Application number 2020/92284/W
33 Wilshaw Road Wilshaw Holmfirth HD9 4DZ
Erection of single storey outbuilding to provide home office / studio (within a conservation area)

PROPOSED PLAN OF STUDIO/OFFICE 1:50 @ A2

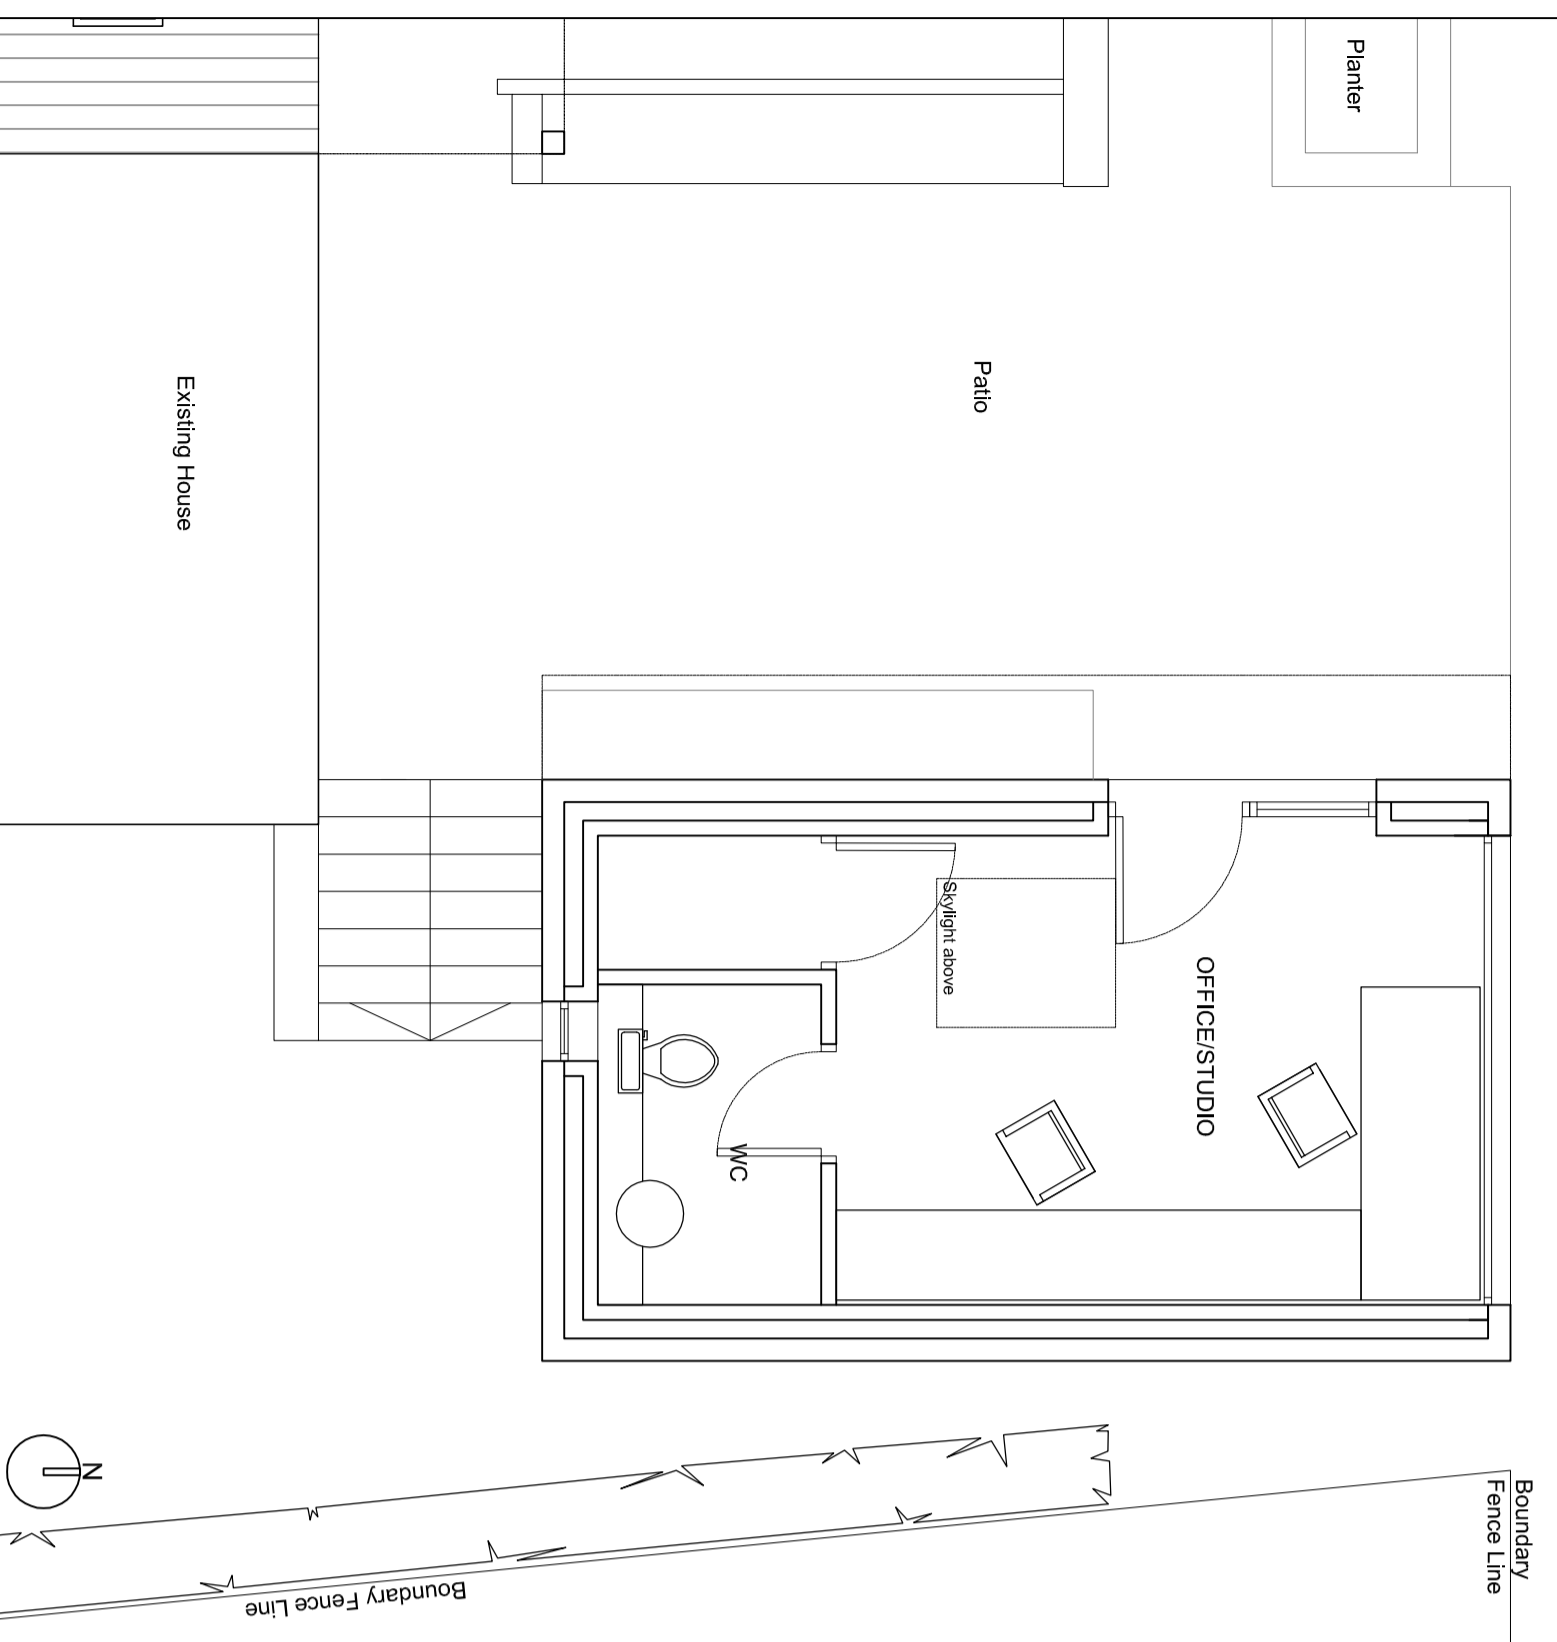
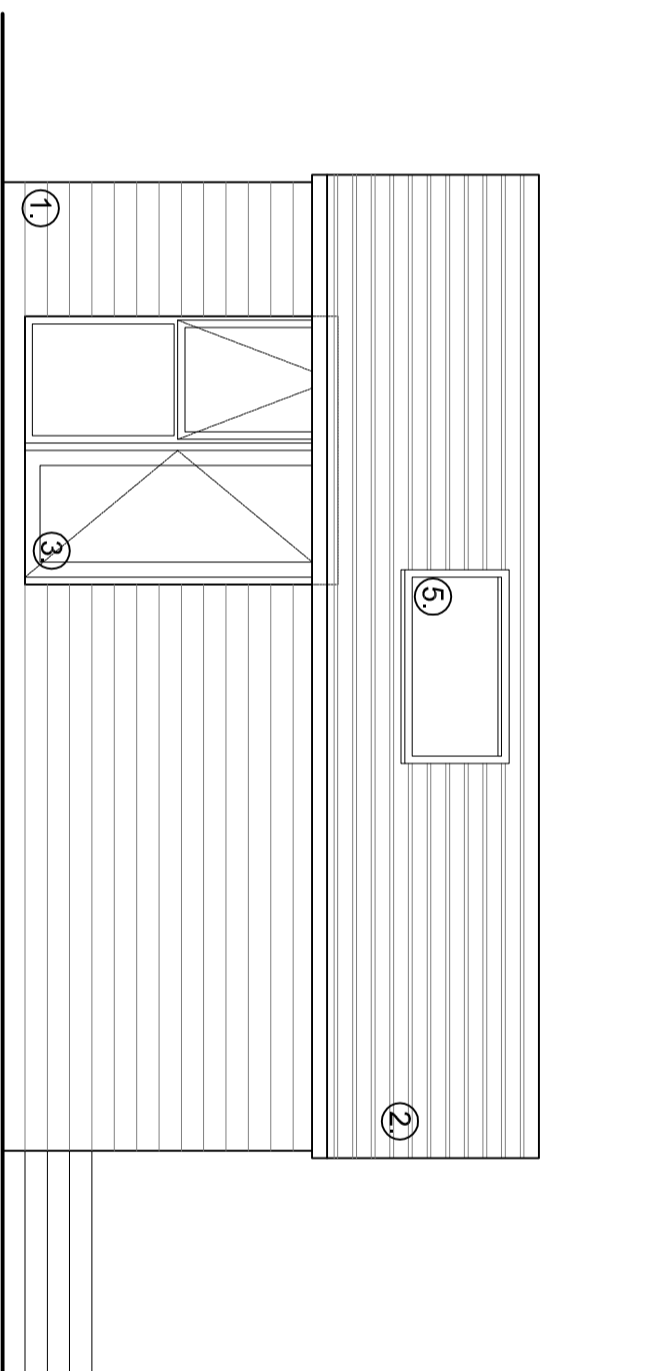
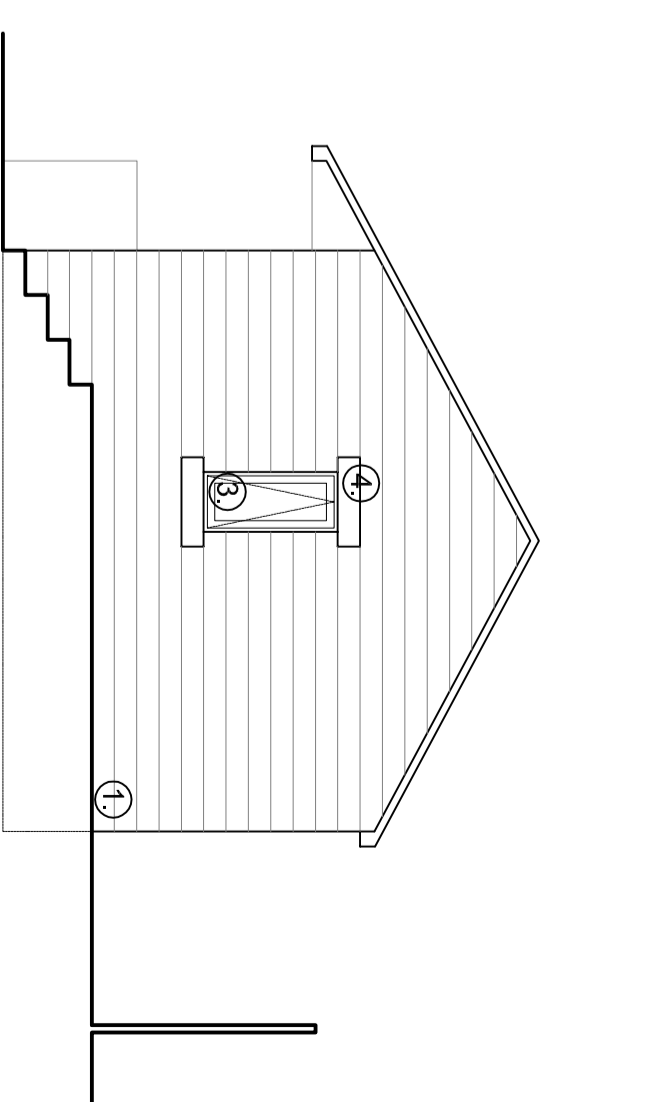
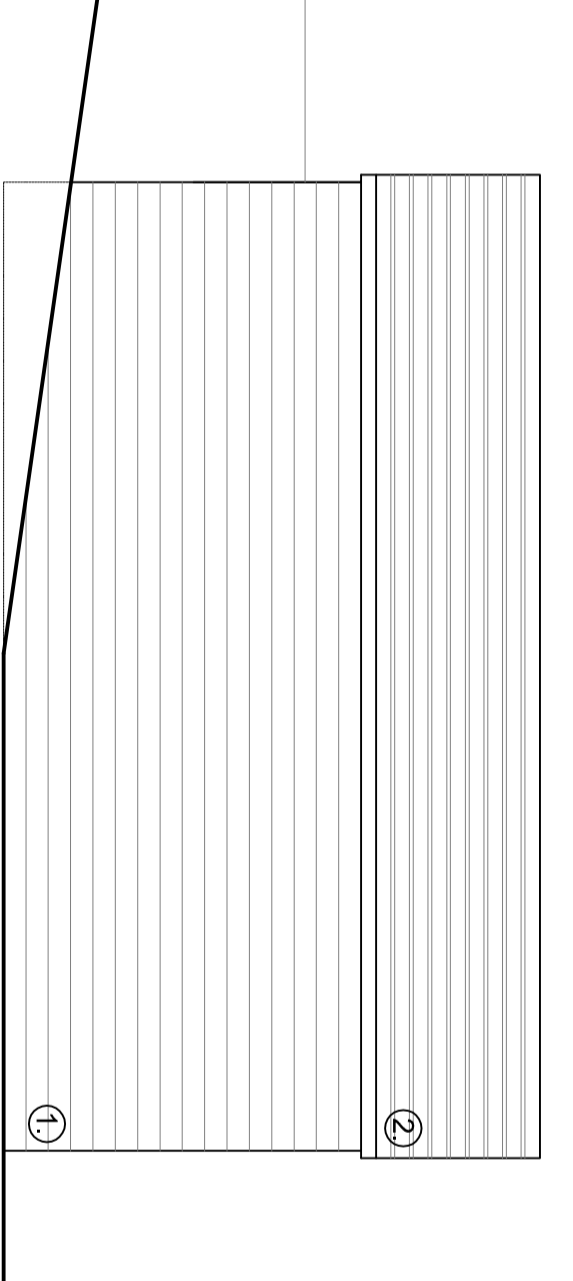
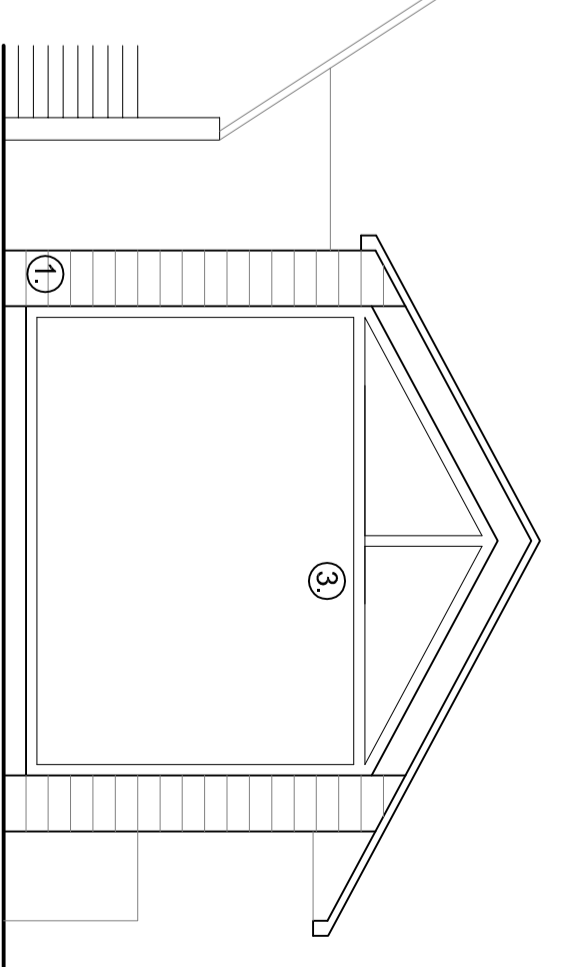
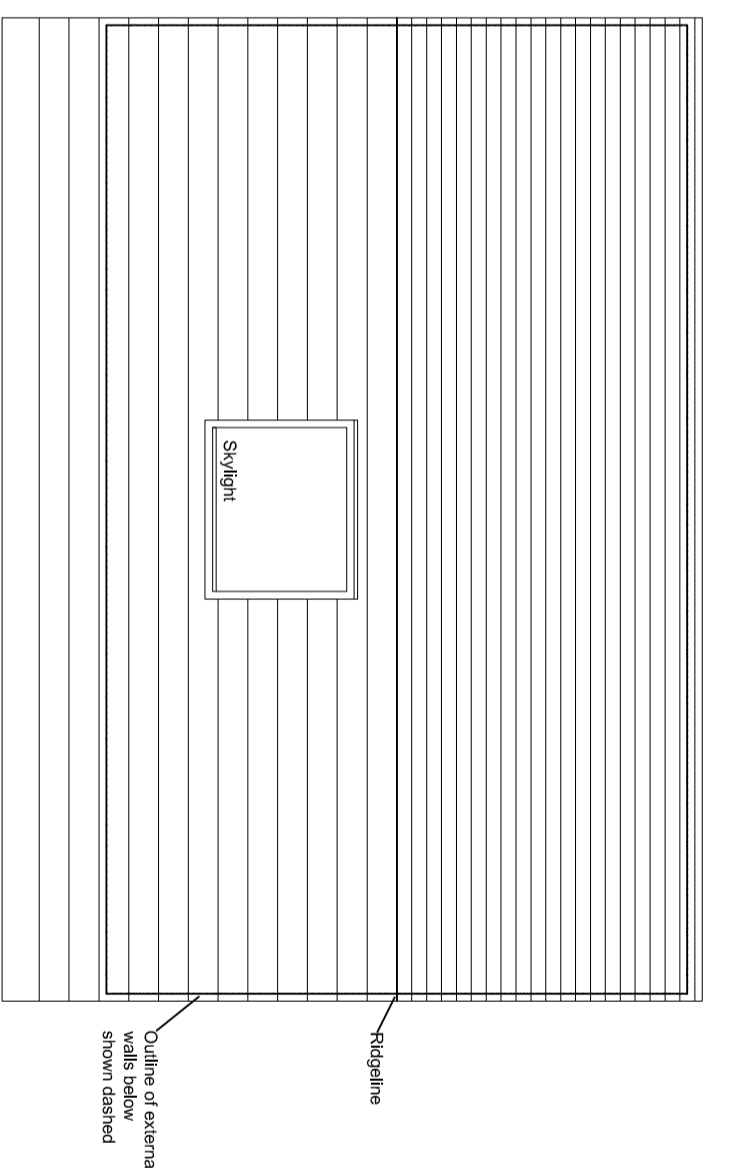
1. The Decision Notice 2017/62/9124/W stated, inter alia, that the external walls and roofing materials of the detached garage should in all respects match those used in the construction of the existing building. The 'existing building' is built of coarsed natural stone not reconstituted stone as detailed in the current application

PROPOSED SITEPLAN 1:250 @ A2

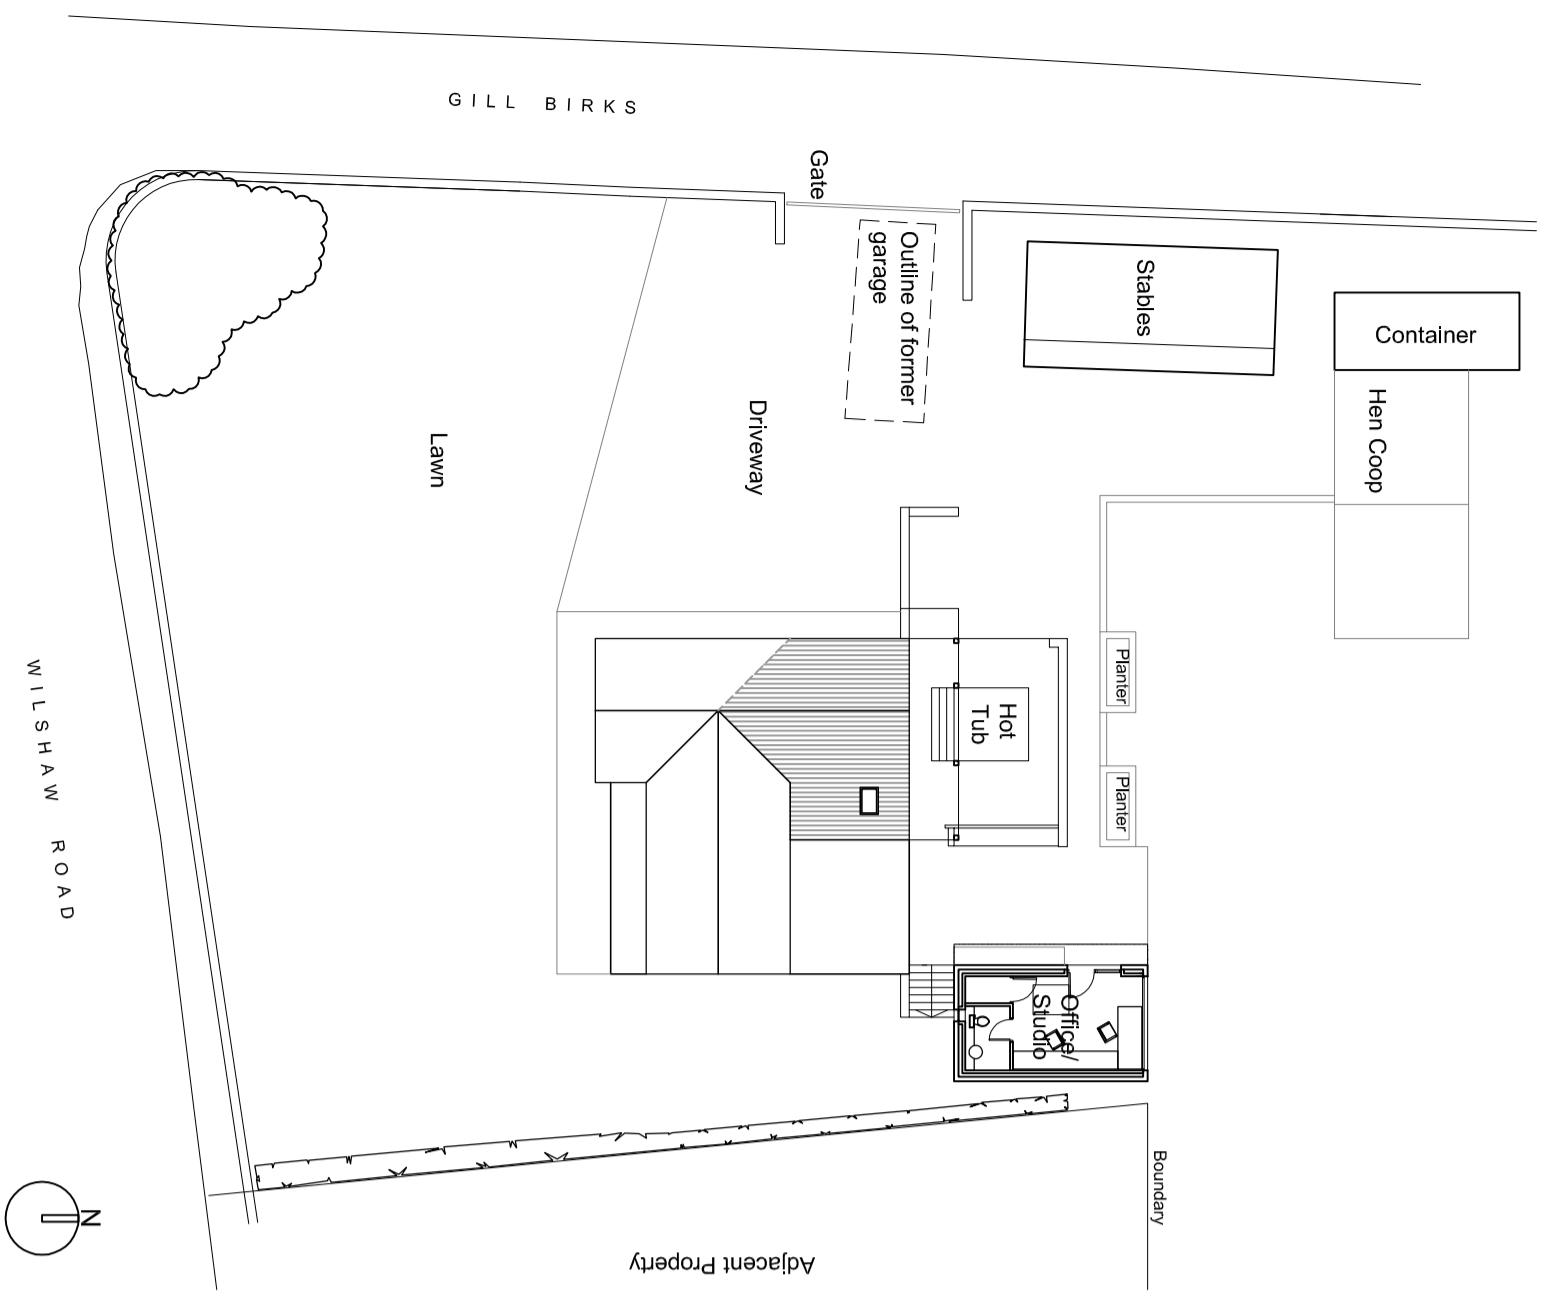
2. Siting the garage (outbuilding) further to the north would cause further harm to the outlook of our adjacent property (Willow Shae). Please appreciate that our amenity has already been seriously damaged by the previous developments on this site and we already have a substantial amount of brick work to look at by virtue of the large extension to the rear of number 33 and the attached walled enclosure. You will note from the planning history of number 33 that the extension should have been 4m in width but we believe that it is actually 4.5m. This obviously reduces the previously open view from our property even further. We then have further walling to look at which was allowed by planning to save the current owners from having to demolish their previously constructed attached garage. Should the current application be allowed to proceed then there will be walling from the front of the building (circa 1940s build) right through to the rear of the domestic plot. An essential characteristic of the Green Belt is its openness. This has already been compromised by the addition of the high gated access, the container adjacent to the public footpath, the erection of the extension and the erection of the walled area which houses the bar-b-que and hot tub, all of which have diminished the open aspect.

- on to our property. The plans submitted make no reference to water drainage. The area to the rear of our property is extremely slippery and unsafe and which is due to water ingress from number 33. We are concerned that this additional building might make matters worse as the groundwater could naturally be forced round the building into our lower level property
6. The proposed works fail to preserve or enhance the conservation area in which they sit, contrary to Chapter 16 of the National Planning Policy framework and policy PLP35 of the Local Plan
